M3 Junction 9 Unique Reference: 20036783

Application by National Highways for an Order Granting Development Consent for the M3, Junction 9 Improvement

Submission

Winchester Action on the Climate Crisis

Client
VolkerFitzpatrick

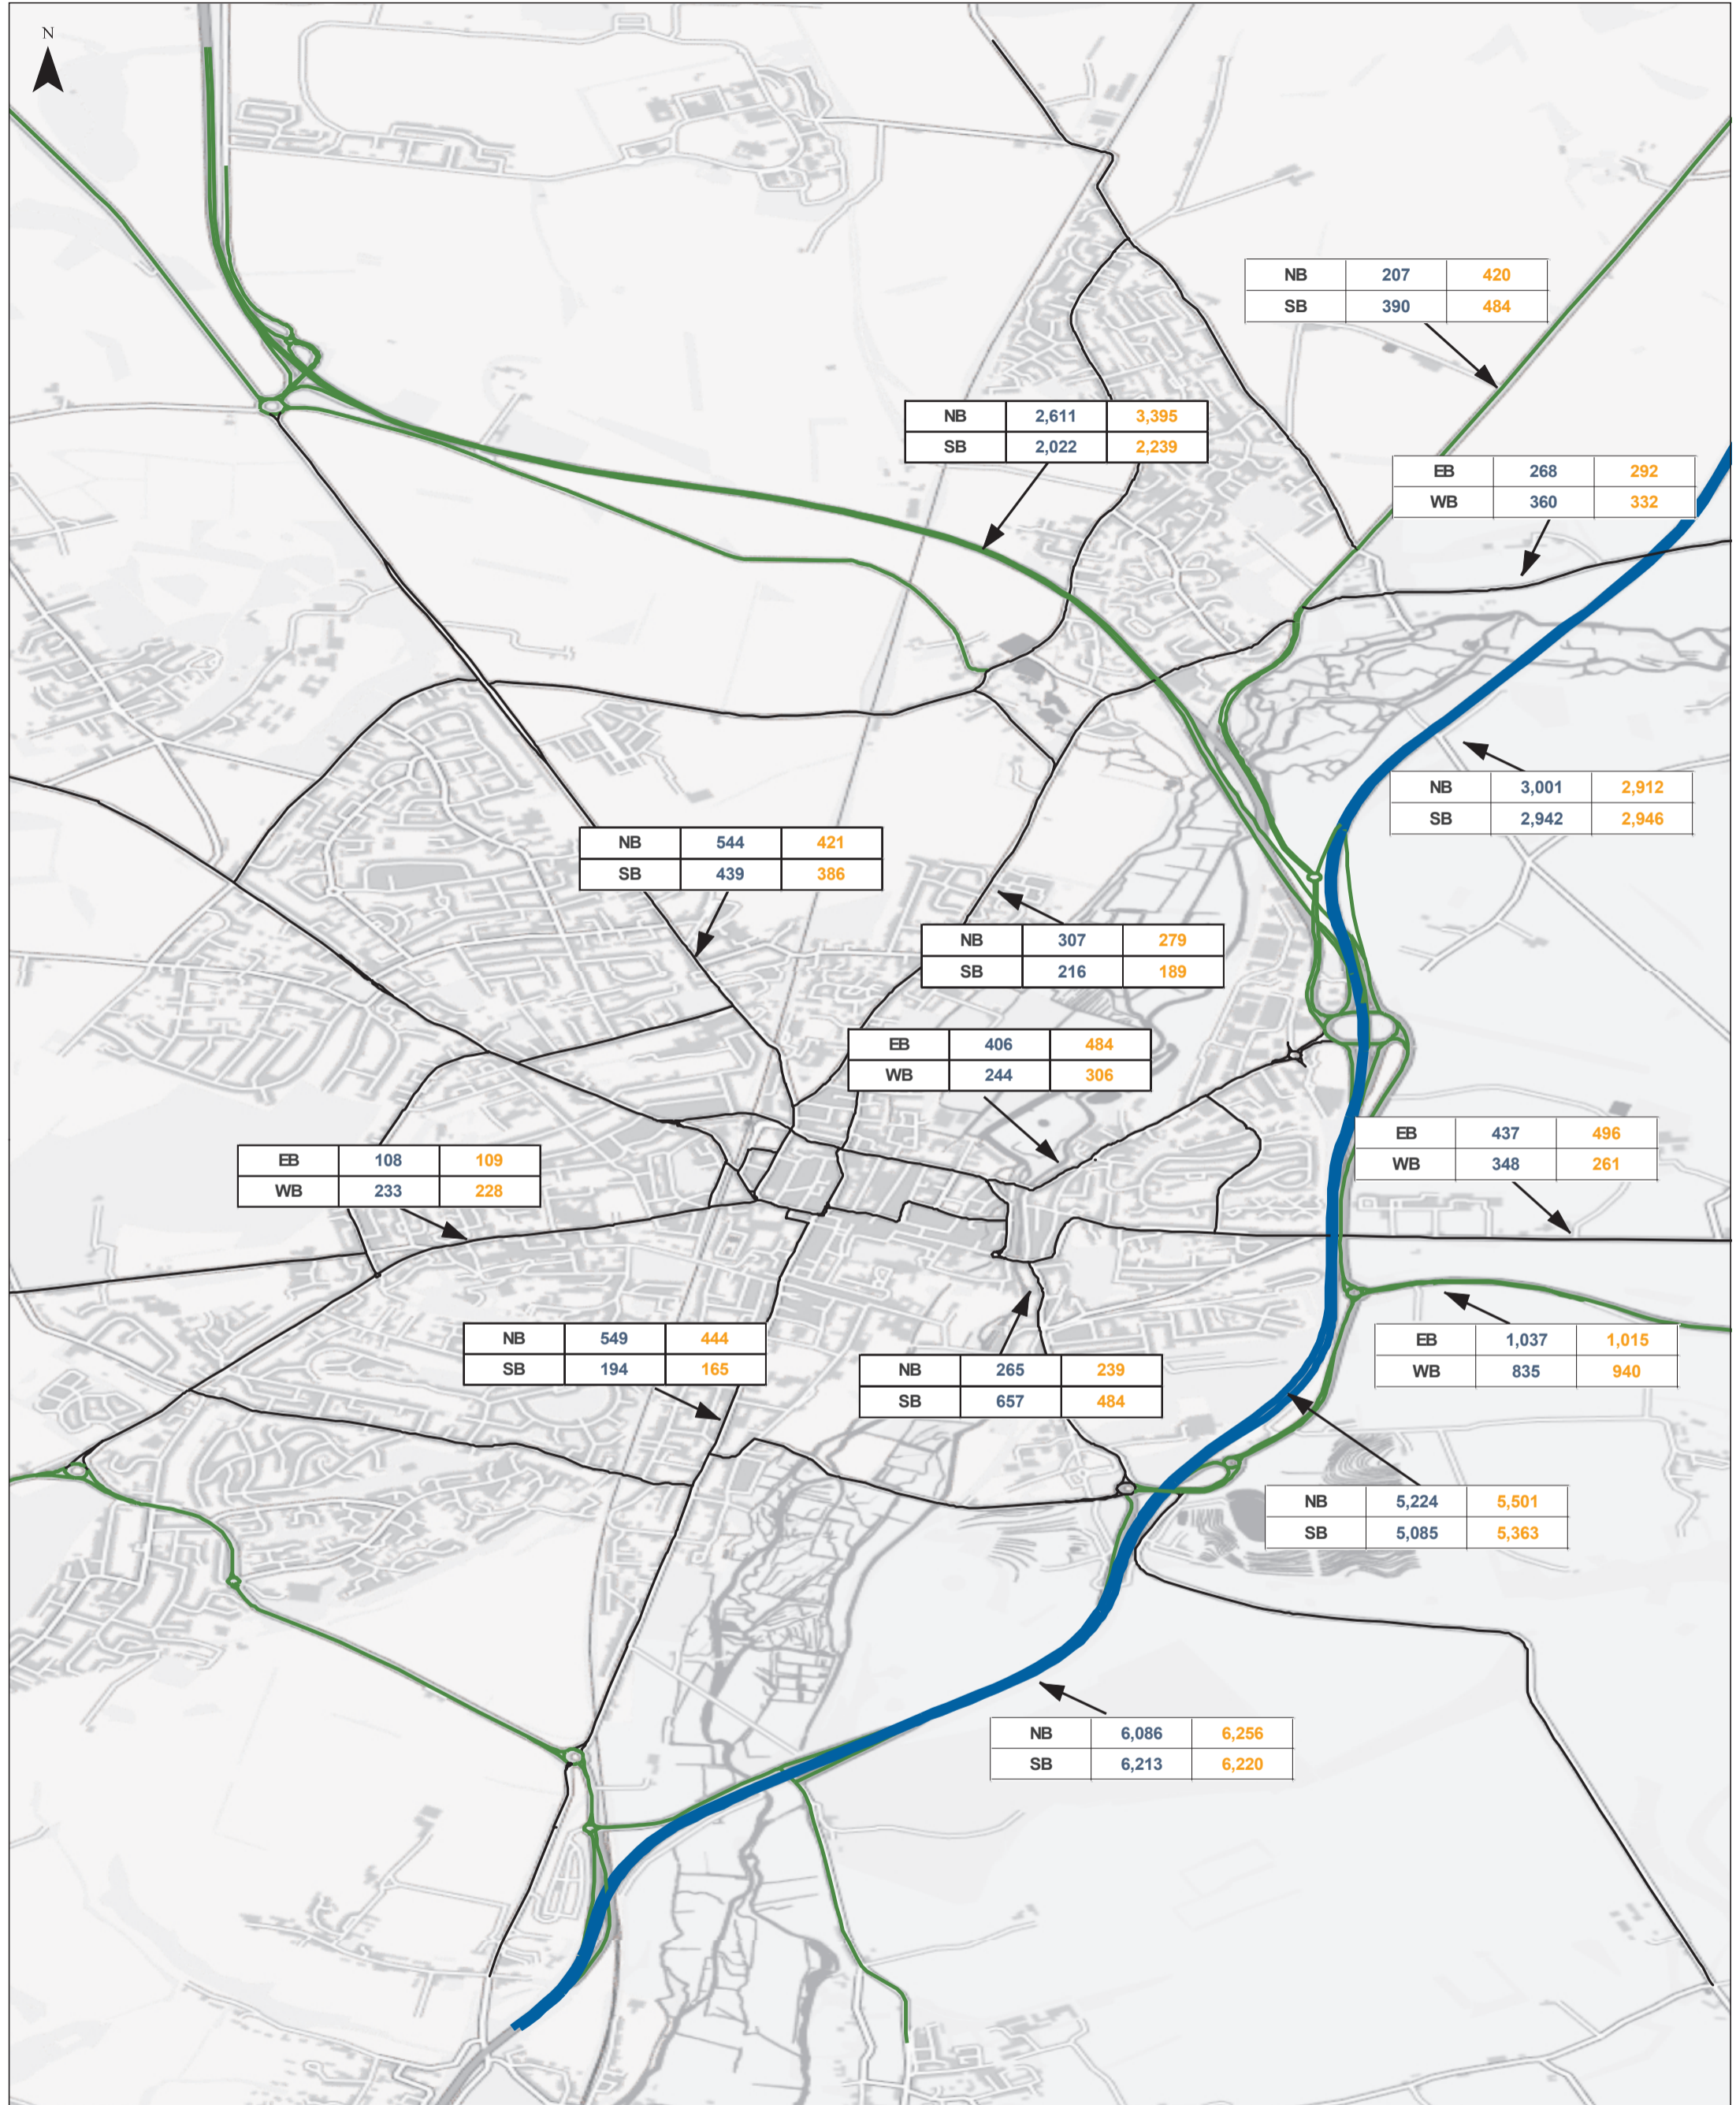
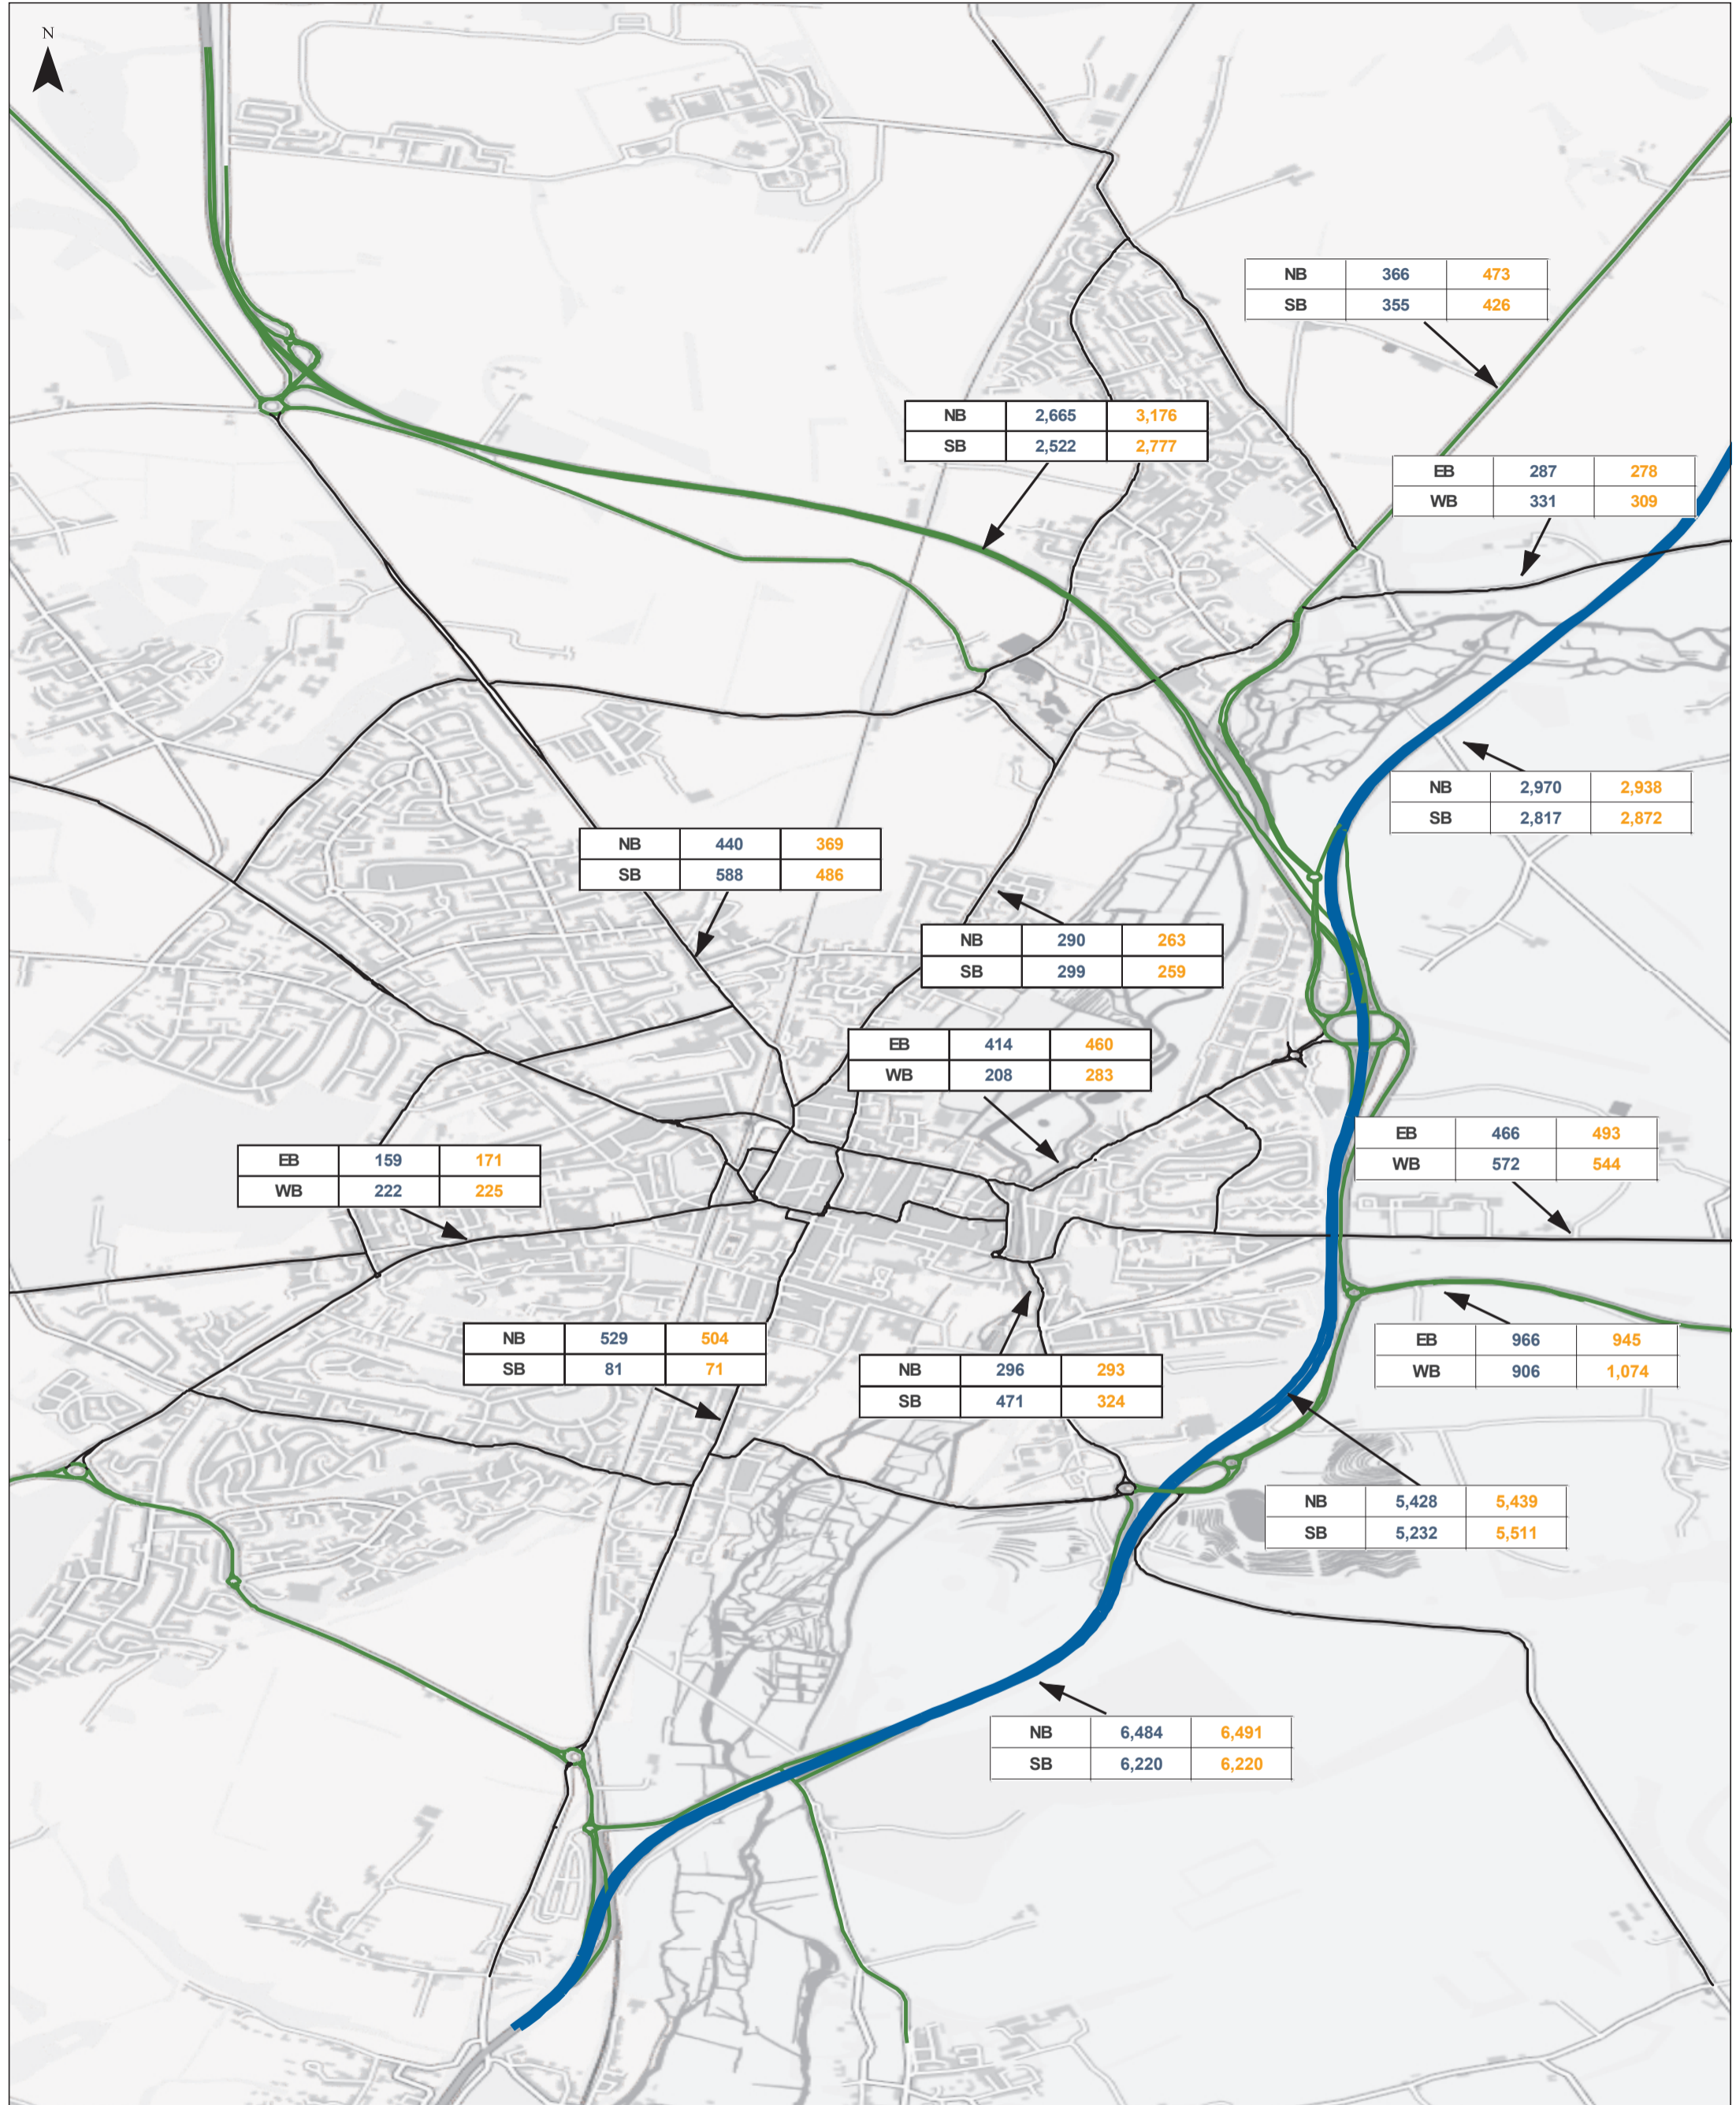
The modelling maps in document [7.10 Combined Modelling and Appraisal Report](#) compare traffic flow if the project does not go ahead (Do Minimum (DM)) with what will happen if the project goes ahead (Do Something (DS)). The final comparison models what will happen in 2047.

In the table below we have added together both directions for the AM peak, the period between the peaks, and the PM peak.

2017	AM+IP+PM		DS/DM%
	Do Minimum	Do Something	
Andover Road	2,843	2,374	83.50%
Romsey Road	1,077	1,092	101.39%
St Cross Rd	2,028	1,779	87.72%
Chesil Str	2,371	1,873	79.00%
Alresford Rd	2,561	2,501	97.66%
Easton Lane	1,712	2,152	125.70%
Worthy Rd	1,640	1,503	91.65%
Petersfield Road	5,392	5,735	106.36%
Local Roads Totals	19,624	19,009	97%
A34N	14,810	17,595	118.80%
A33N	1,986	2,183	109.92%
M3N	17,308	17,260	99.72%
M3 Sports Centre	31,704	32,689	103.11%
M3 Twyford Down	37,455	37,670	100.57%
Strategic Roads Totals	103,263	107,397	104.00%
Full total	122,887	126,406	102.86%

There are some roads that will suffer major traffic increases: especially Easton Lane, and the A34 as it passes through King's Worthy. Some roads will benefit from major decreases such as Chesil Street and Andover Road.

However the overall picture is one of very little change. It is very surprising that the modellers predict a small reduction in traffic along the M3 from Winchester to Basingstoke. It will reduce traffic levels within Winchester Town very little.

The report above accepts that induced demand is a significant phenomenon. In the worst cases, especially where there is traffic congestion, traffic will increase to fill the available space. The applicant proposes doubling (at least) the carriageway width on the route through the junction linking M3S and A34N in both directions. In a situation like this it would not be unknown for traffic to double. This route does show the greatest two-way traffic increase across the 20 year modelling period but the increase of 26% predicted by the modelling understates the likely results of a 100% capacity increase:
